Our ref: XA/2025/100338/03-L01

Your ref: EN010157

Date: 10 September 2025

ENVIRONMENT AGENCY RESPONSE TO DOCUMENTS SUBMITTED AT DEADLINE 1. PEARTREE HILL SOLAR FARM, EAST YORKSHIRE.

SCALE AT A3: 1:20,000	DATE: 03.07.25	DRAWN: AB	CHECKED: PG
PROJECT NO: 20-206	DRAWING NO: 60-315	REVISION: 01

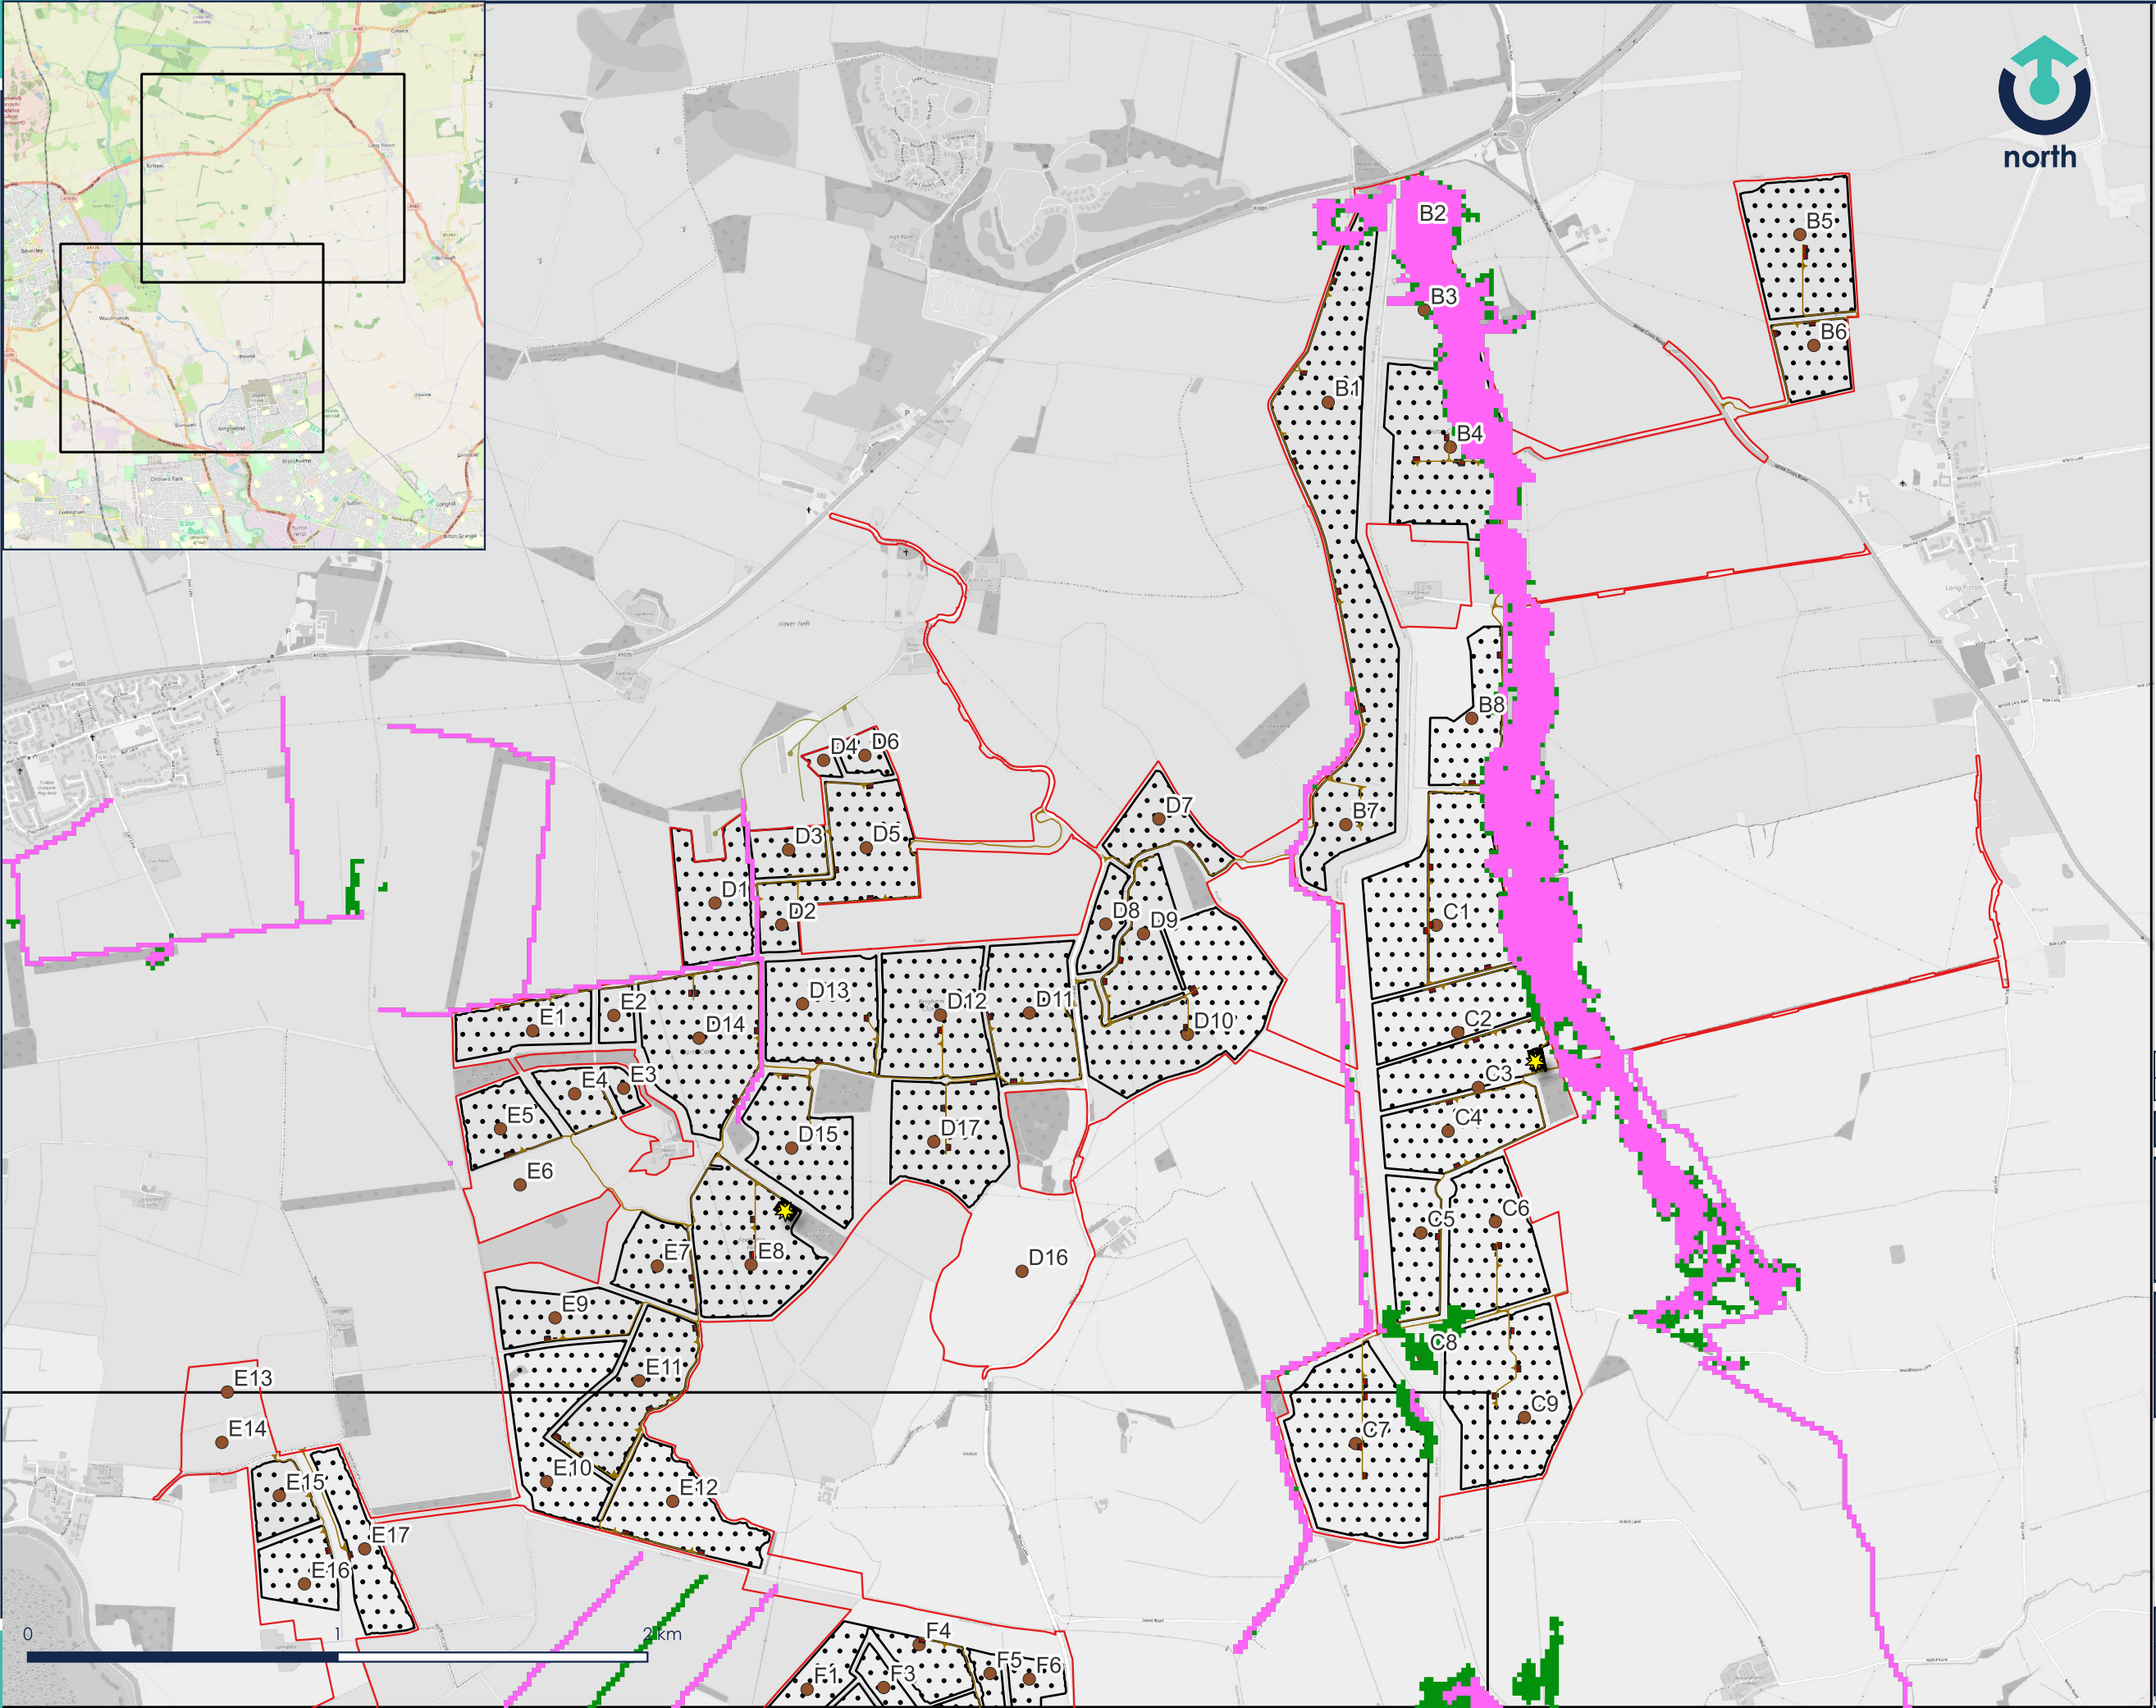
We have reviewed the updated flood risk assessment (FRA) [[REP1-032 – REP1-049](#)]. A plan which includes the 1 in 50 annual probability extent is shown within Appendix B of the updated FRA (drawings 60-315 and 60-316). This extent is only marginally larger than the 1 in 20 annual probability extent and would constitute a suitable and conservative proxy for functional floodplain.

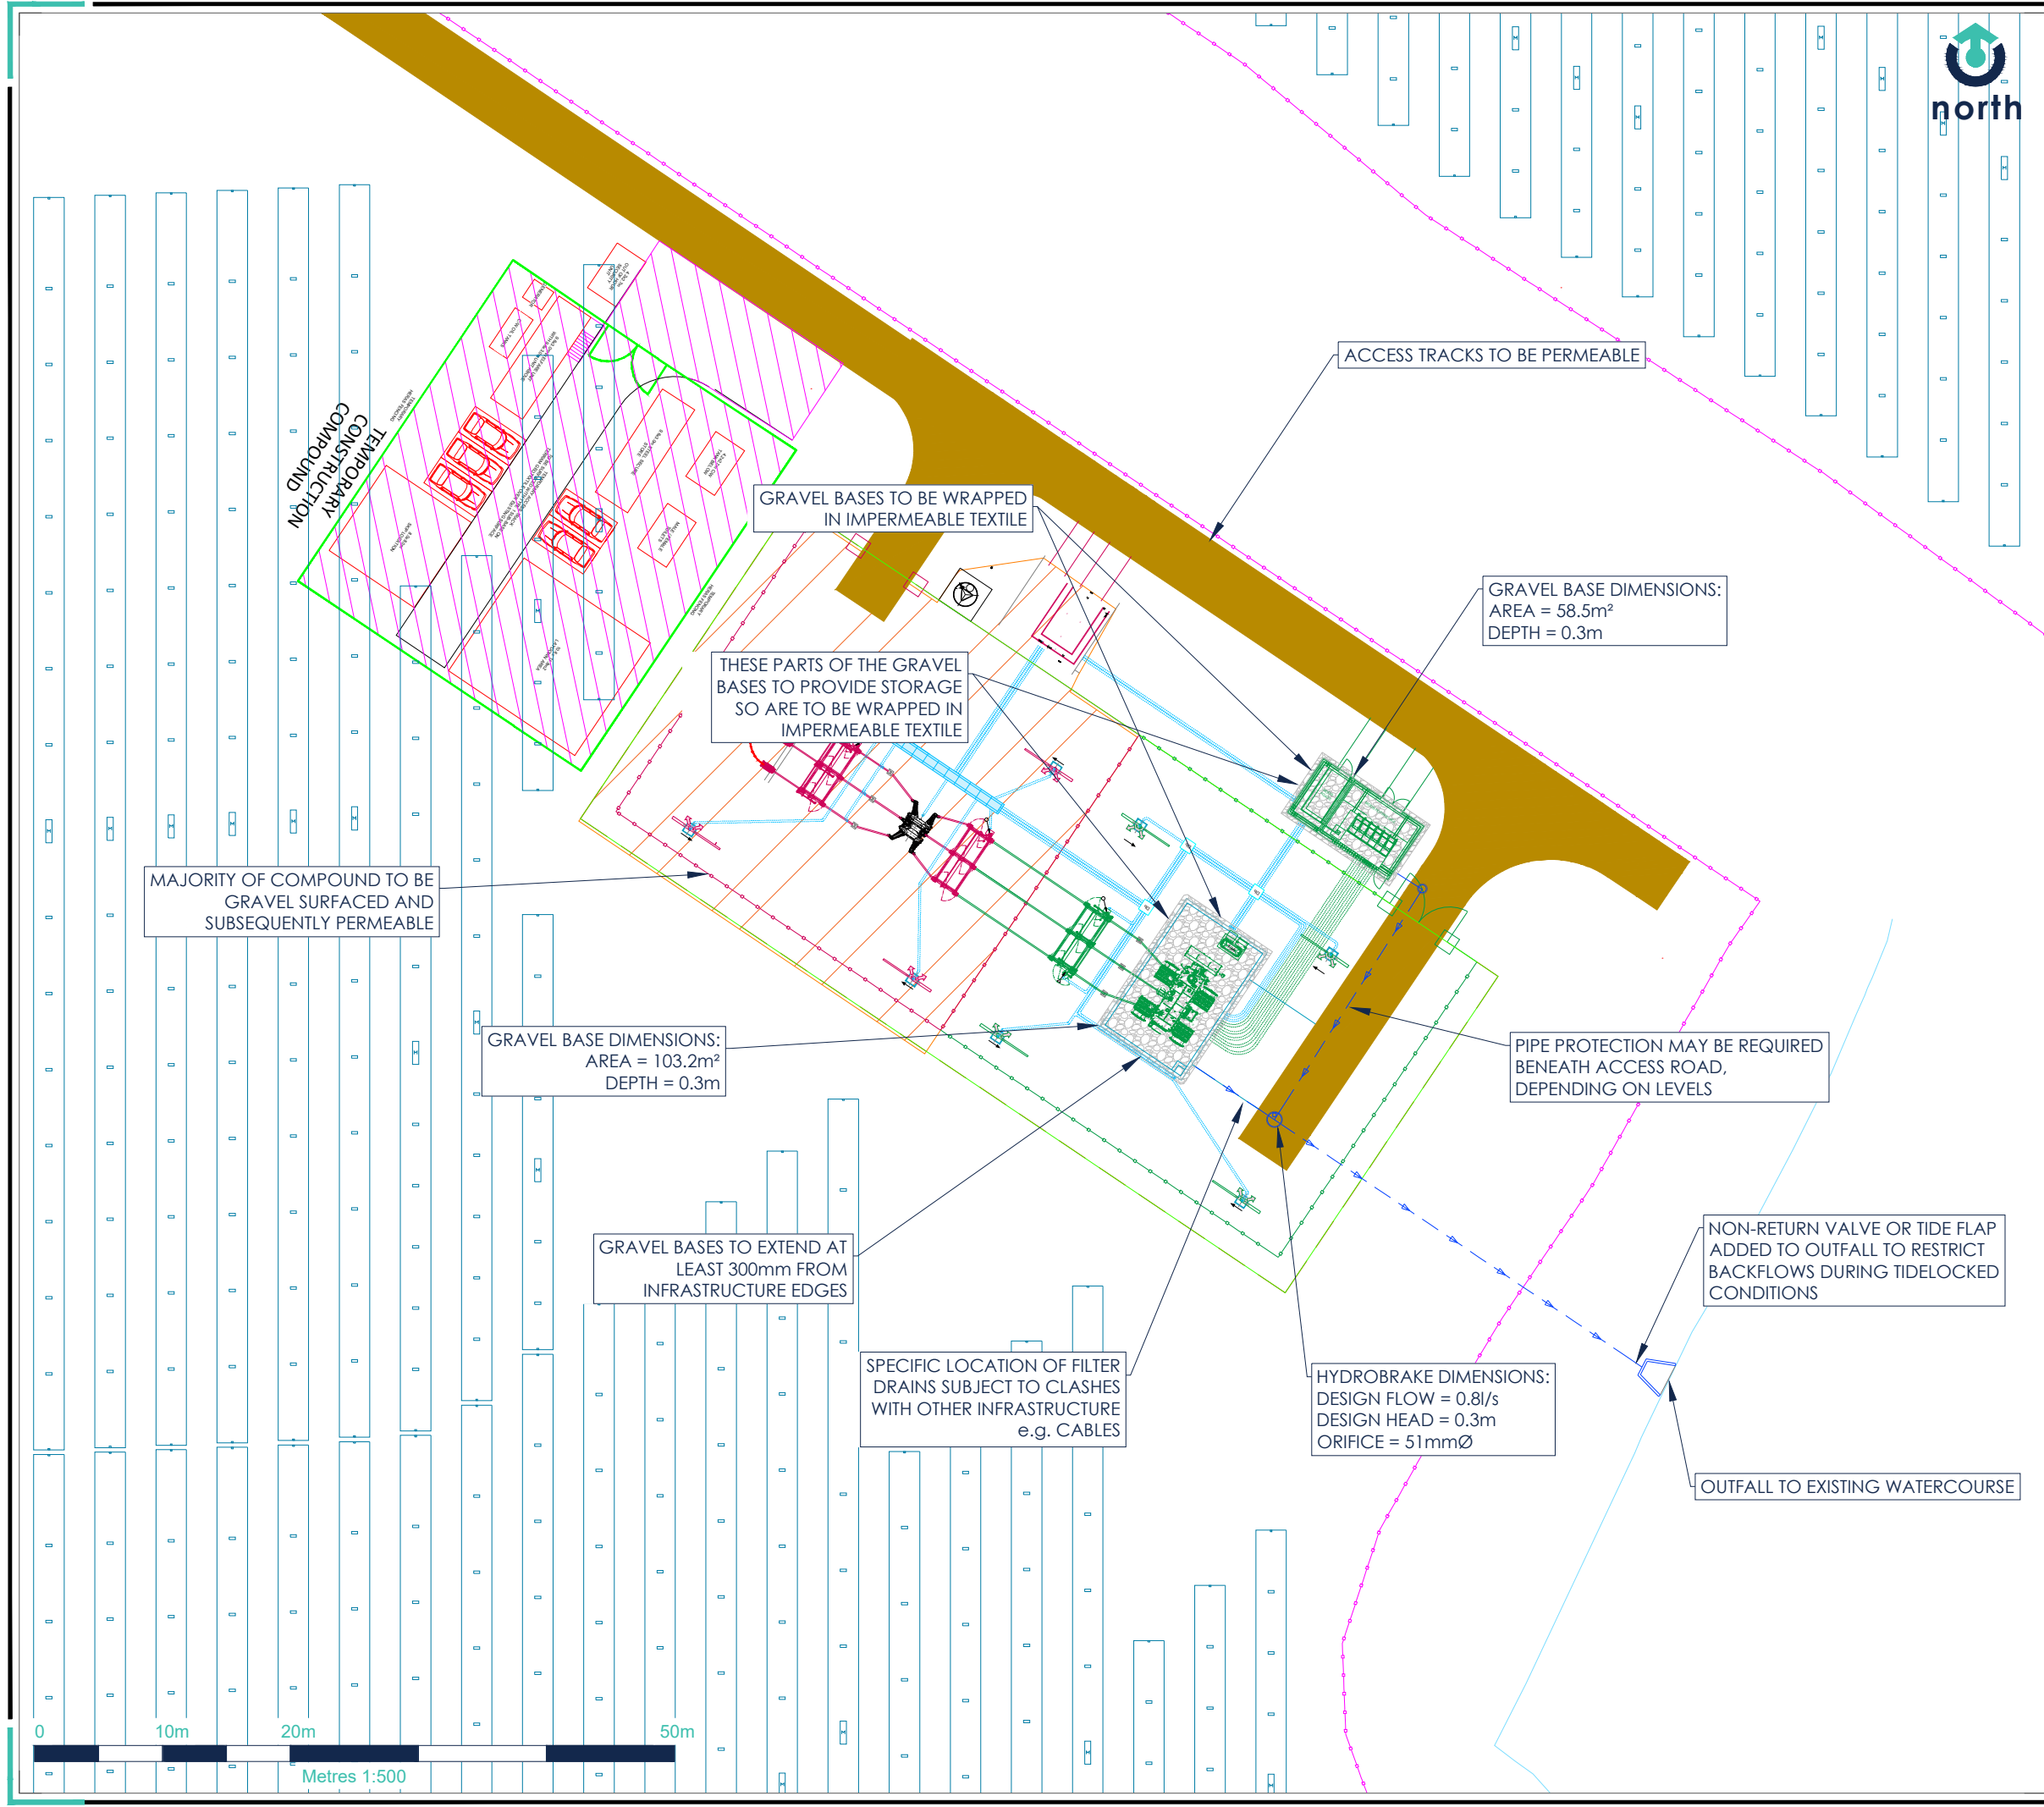
The National Fire Chief Council's guidance has not been implemented with respect to giving consideration, within the site design, to the management of water run-off (e.g. drainage systems, interceptors, bunded lagoons etc) or using water-based suppression systems. Water used to cool adjacent BESS containers can still result in contamination should the containers fail. Therefore, containment of firewater and use of impermeable liners is best practice and should be implemented. Furthermore, in the event of a fire, a gravel base will be much harder to clean following any contamination.
